Application No: P/86/22/HH
Site Address: Rose Cottage Priors Way Pagham PO21 3JU
Description of works: Single storey front extension, following demolition of existing swimming pool.

Thank you for your internet representation made on 19th June 2022 which has been recorded as an objection with the comments as follows:

PROPOSED GROUND FLOOR PLAN

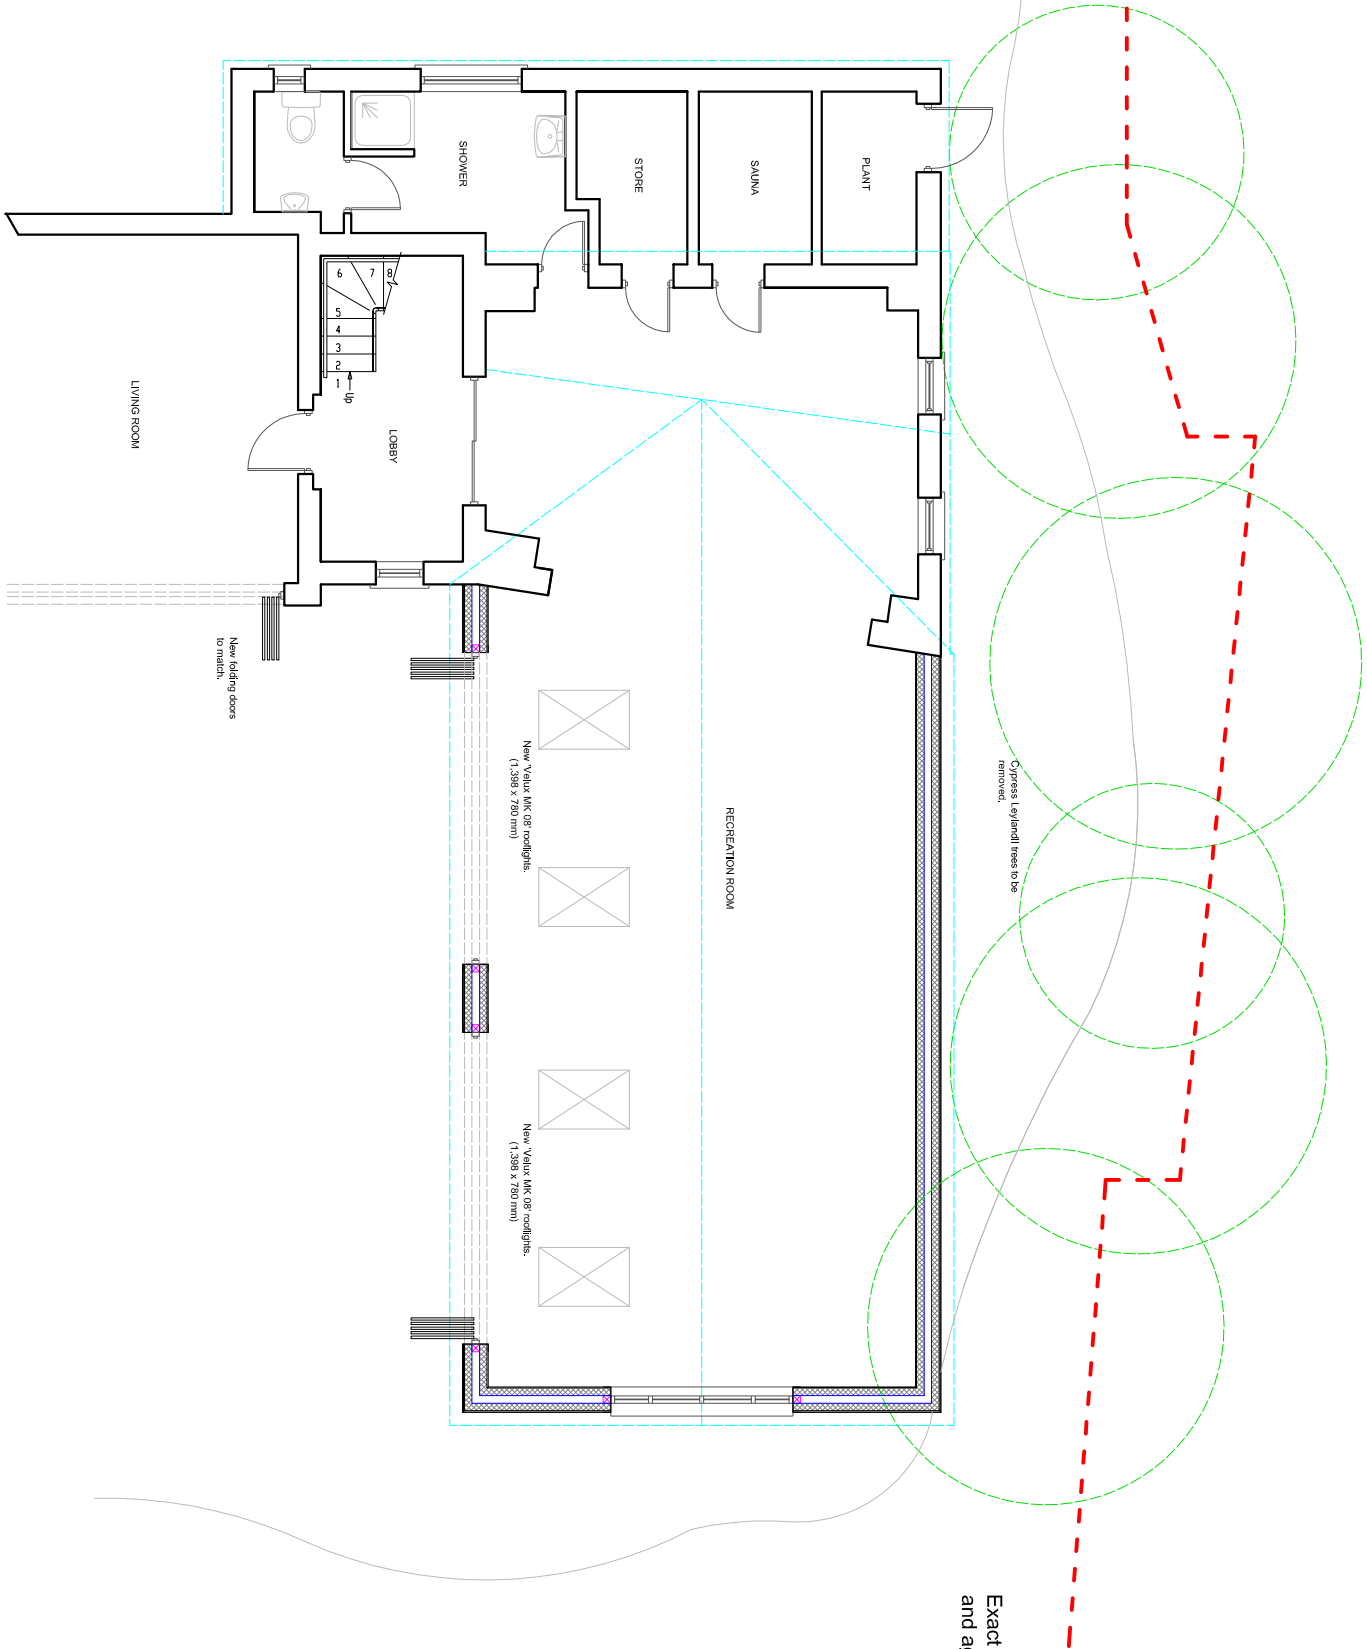
upon further inspection of the proposed plans for this extension i am further objecting to this due to the closeness of the proposed building to our boundary.

I have reviewed our title deeds (wsx192943) and our plans showing our boundary lines do not match the boundary lines shown on the proposed plans.

another concern is the vicinity of the proposed plan to the main drain which runs through the boundary line.

EXISTING GROUND FLOOR PLAN

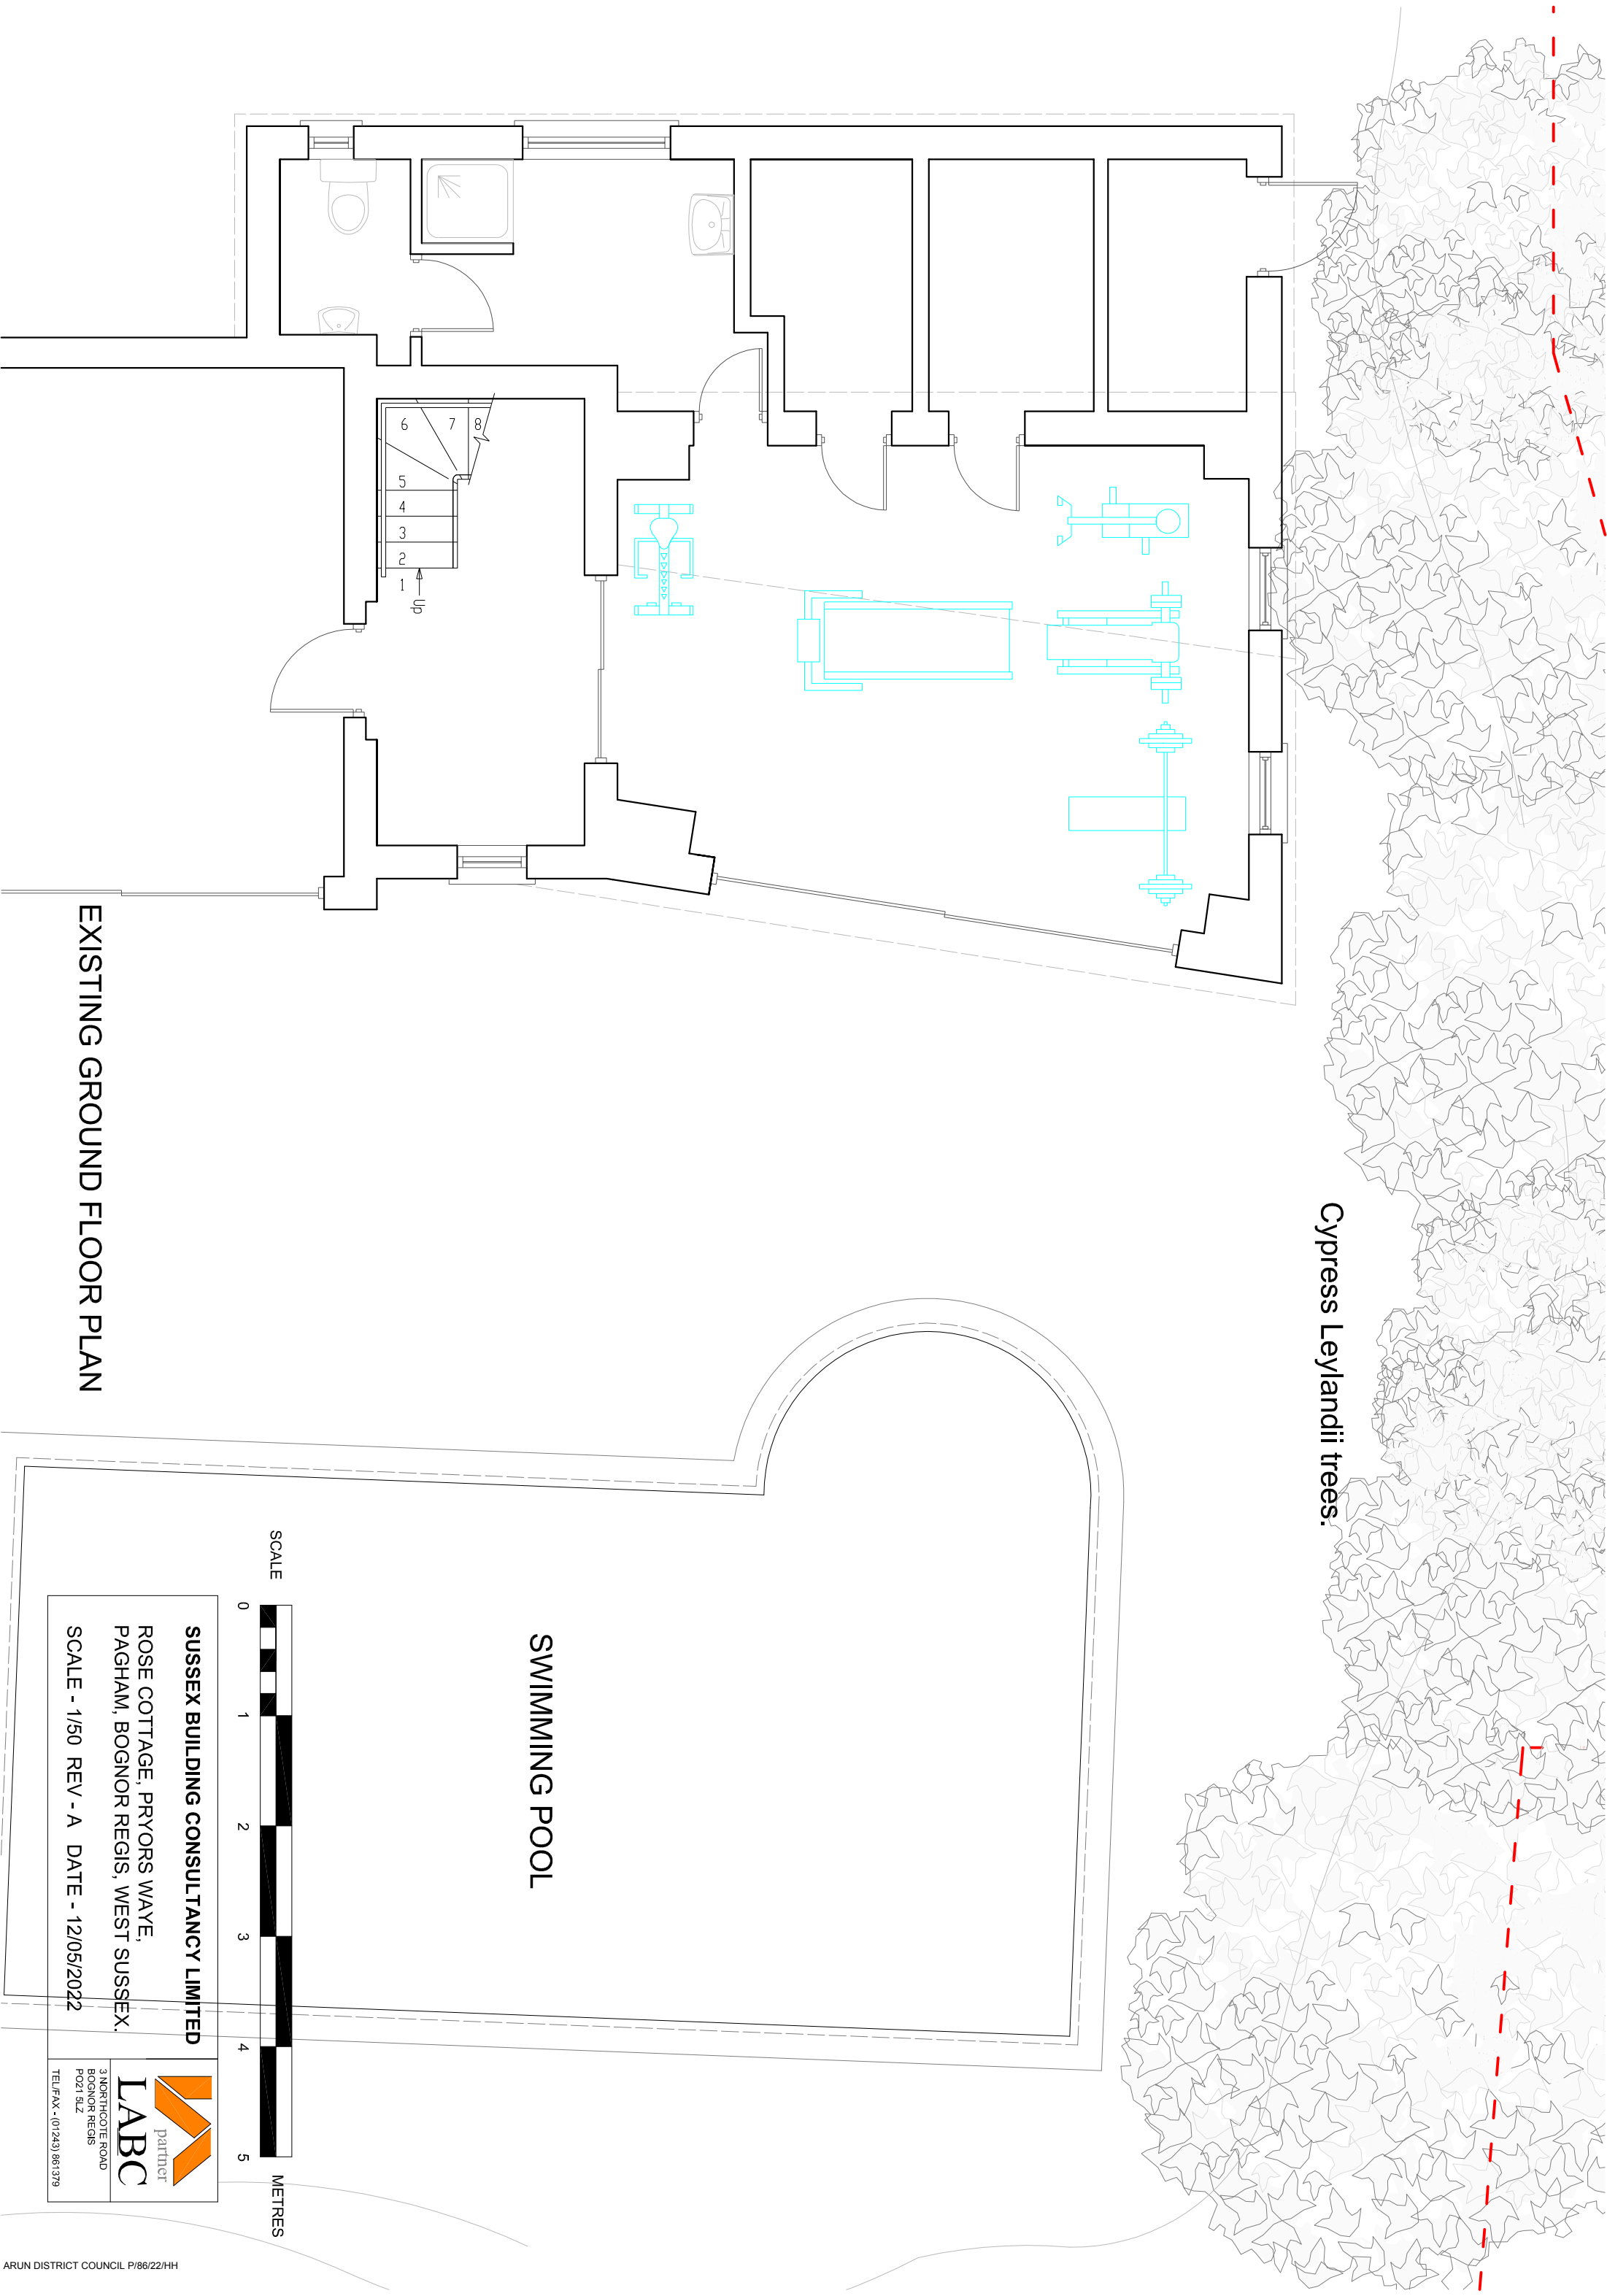
i have further concerns around the removal of the leylandii trees and the probable subsidence of the base/foundations of our shed that is situated at the end of our garden and the probable destruction of our fence also at the bottom of our garden.
